Submission Form

Epping to Thornleigh Third Track Proposal. Application number SSI 5132.

Figure S.6 Cross-section and elevation - New Cheltenham Station concourse building (see also S.5 for artist's impression)

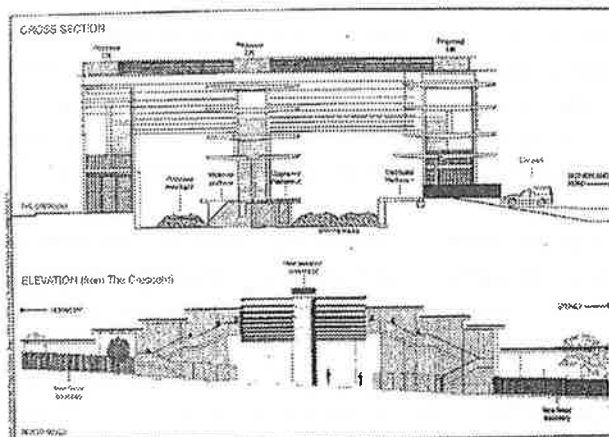
- The proposed redevelopment of Cheltenham Station shows no regard for the HCA. The visual impact of the proposed 13m high glass and steel concourse is totally unacceptable in this HCA.
